Kevin Cox
Crime Prevention Design Advisor
Thames Valley Police Headquarters South
Oxford Road
Kidlington
Oxfordshire
OX5 2NX

REF: 21/02467/F

Location: OS Parcel 0005 And Part OS Parcel 1300 0878
And 7566, Banbury

09 September 2021

ground floor

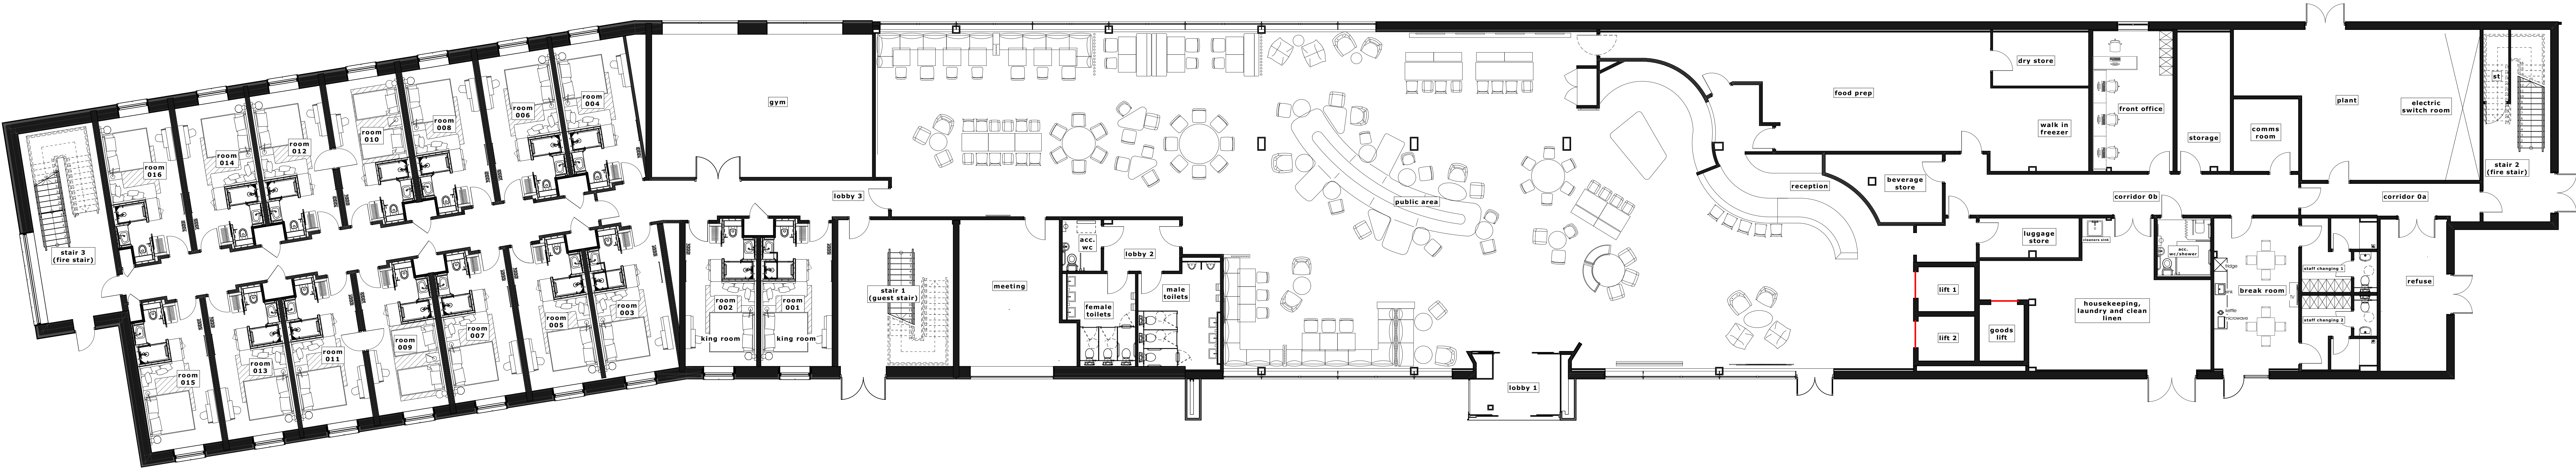
- Plans indicate externally opening doors within all ground floor stairwells, potentially providing access into the residential corridors bypassing the reception desk. There is a risk that unless access controlled, these doors may support and facilitate crime, allowing guests to permit access to the internal corridors and stair/lift cores bypassing reception and out of sight of hotel staff. Child exploitation, both sexual and drug related, are emerging crime trends that are particularly prevalent in hotel environments. For this reason it is vital that all guest movements to and from the hotel should be via the permanently staffed hotel reception, where trained staff are able to monitor guest movements and potentially detect and report such activity. The risk of this type of activity occurring within this hotel is heightened given its direct access from the motorway, which may assist cross border offenders who are known to use MSA facilities to conduct unlawful business. In order to mitigate the risk of ground floor doors being exploited, I ask that they are secured as a fire emergency egress doors only. Additional information relating to the security of the fire egress doors must be provided, this should include the proposed locking mechanism (mechanical crash bar or electronic lock release (green break glass), and confirmation that the doors will be alarmed. The fire egress door must not be fitted with external furniture and include a visual door panel allowing individuals to observe the area immediately outside before opening the door.

- It is unclear from plans provided whether ground floor bedrooms will be fitted with opening windows for ventilation. I ask for clarity on this point to be provided by the applicant. If the ground floor bedrooms will have opening windows, there must be a minimum 1m defensible space and planting to all accessible GF windows, and windows should be fitted with restrictors to limit opening.
